**Planning Department
Transportation Development Services**

July 23, 2015

**Re: Commercial Self Storage
101 – 106 Mescalero Rd., NW
Submittal for Certificate of Occupancy – Transportation Development
Engineer's/Architect's Stamp dated 4-13-15 (G15-D009)
Certification dated 7-7-15**

TRAFFIC CIRCULATION LAYOUT
for
101 and 106 Mescalero Rd. NW
Albuquerque, NM 87107
APRIL 13, 2015

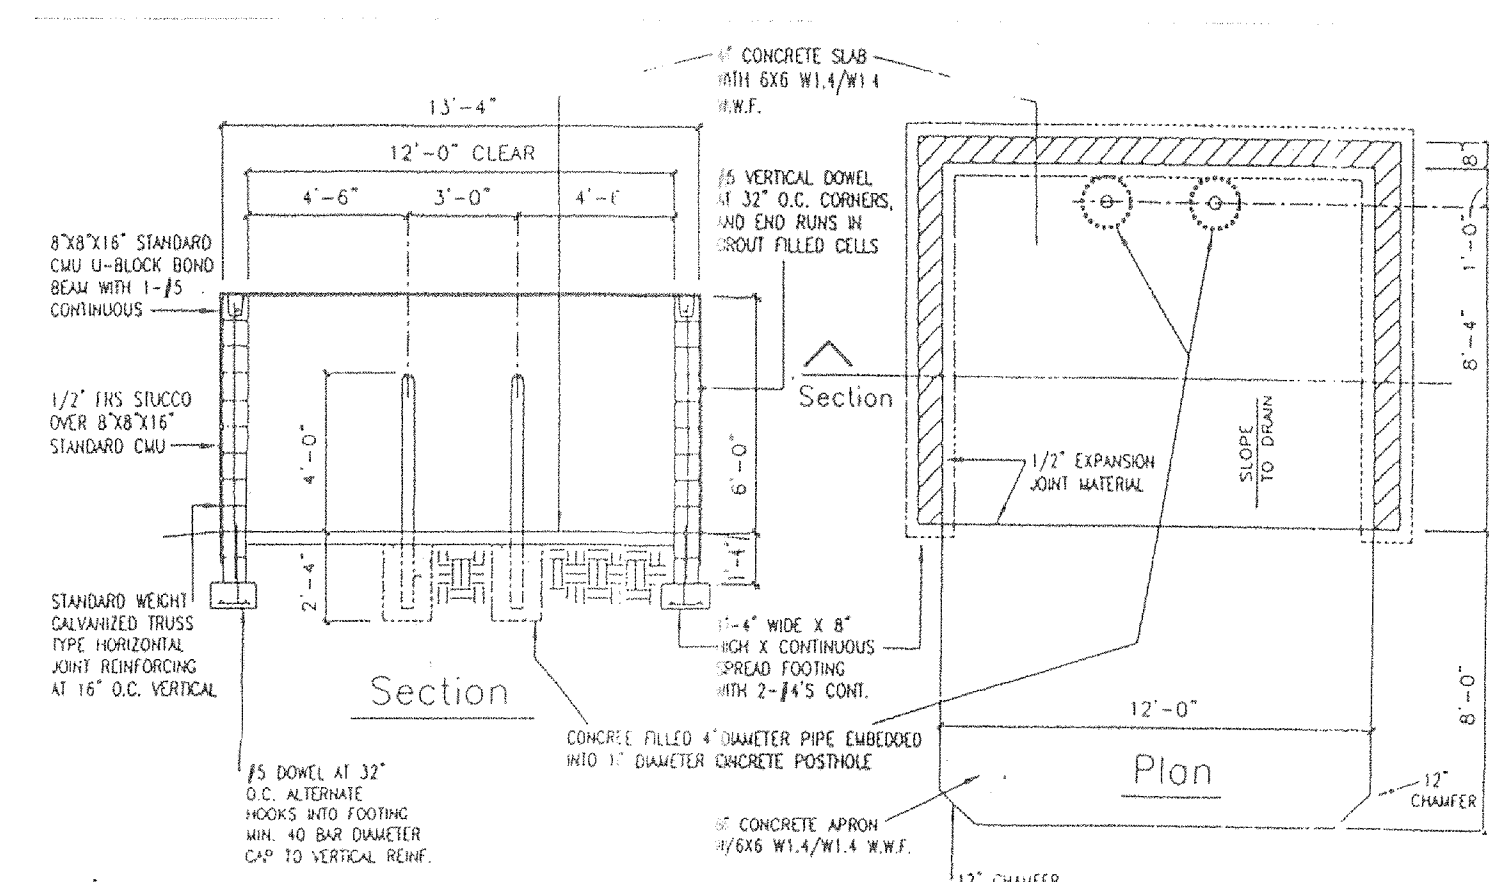
- The ADA van accessible sign must have the required language per 66-7-352.4C NMSA 1978 **"Violators Are Subject to a Fine and/or Towing."** Upon inspection, there was no visible signage with this notation.

- The ADA access aisle shall have the words **"NO PARKING"** in capital letters, each of which shall be at least one foot high and at least two inches wide, placed at the rear of the parking space so as to be close to where an adjacent vehicle's rear tire would be placed. (66-1-4.1.B NMSA 1978)

- Per the DPM, a 6 ft. wide ADA accessible pedestrian pathway is required from the public sidewalk to the building entrances. Please clearly show the pathway to the complex's office. Upon inspection on 7-23-15, there is no ADA access to the office.

- Upon inspection, the ADA parking spaces in need of asphalt repair and repainting of ADA symbol. The ADA parking spaces were also being utilized for the loading and parking of non-handicap customers. This space must be utilized only for handicap customers. Please verify the dimensions of the handicap parking space and the access aisle.
